Flood Management Consultation

Consultation on Application Number: 2016/92298

Address: Former North Bierley Waste Water Treatment Works, Oakenshaw, Bradford, BD12 7ET

Proposal: Outline application for re-development of former waste water treatment works following demolition of existing structures to provide employment uses (use classes B1(c), B2 and B/) and residential use (use class C3)

Drg No:	Rev:
<b>065646-FRA-105</b>	<b>B</b>

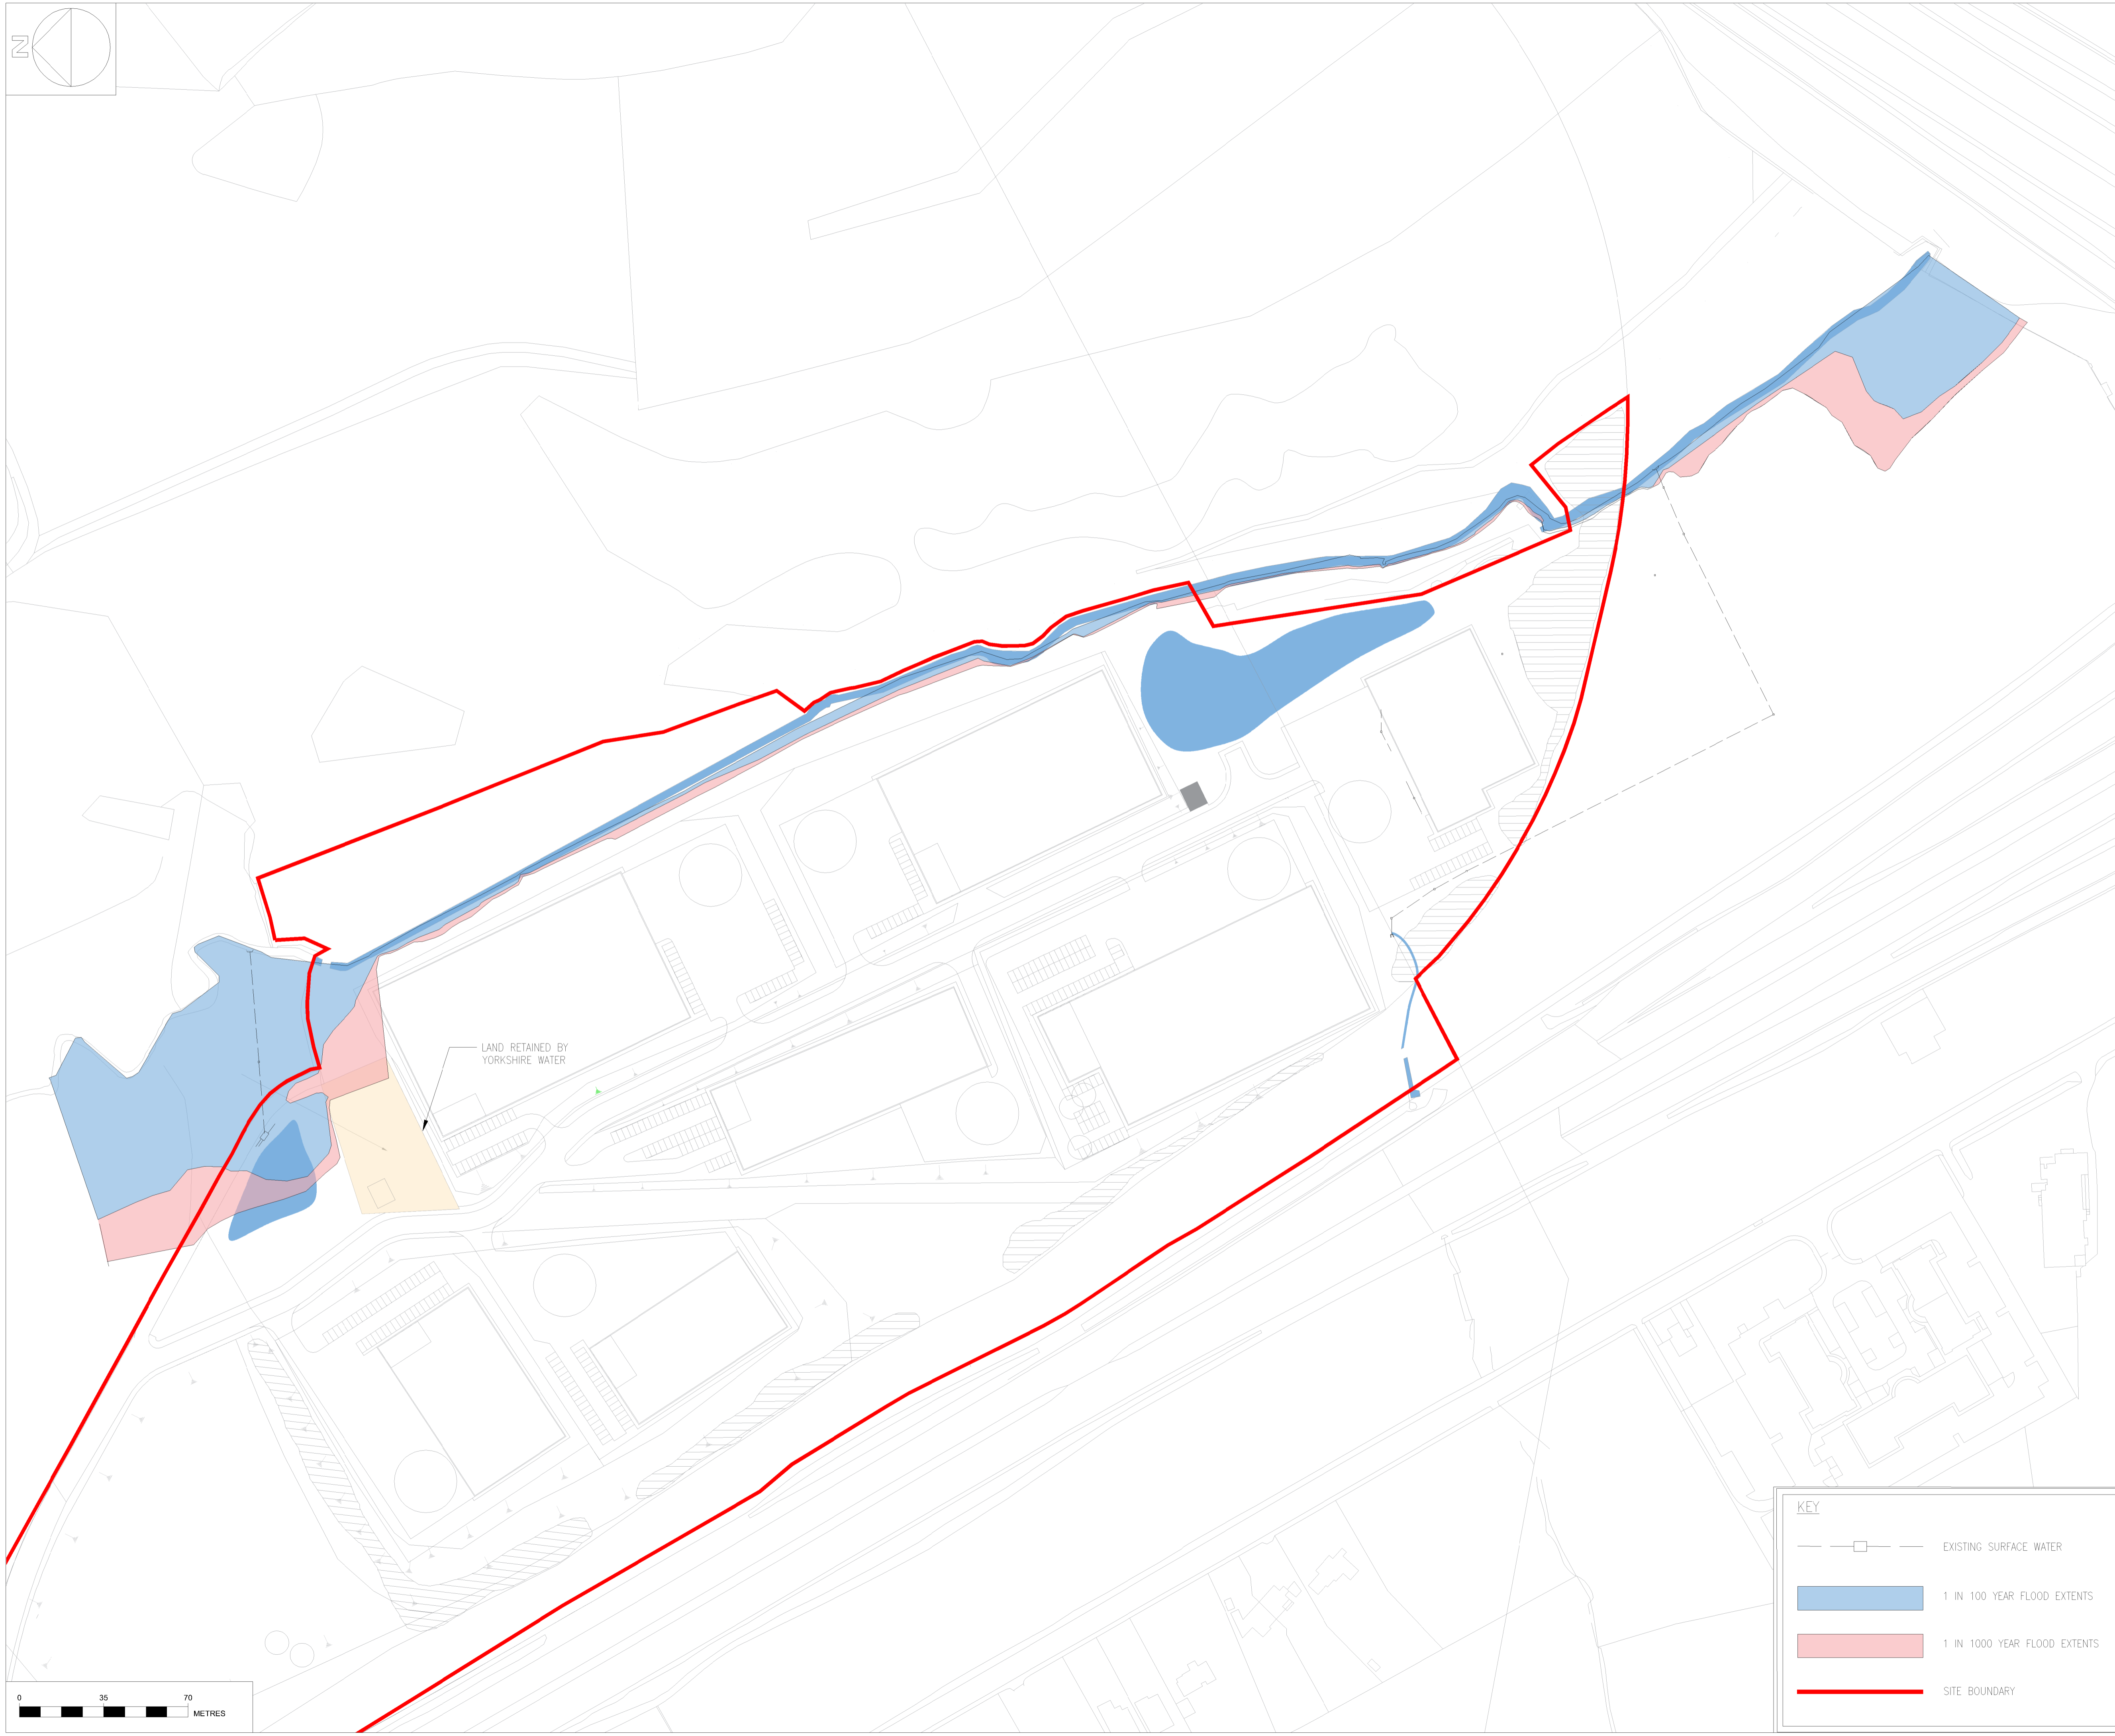
Ensure all residential and commercial buildings and their servicing access roads are located outside of the 100 year flood outlines determined by the FRC model.
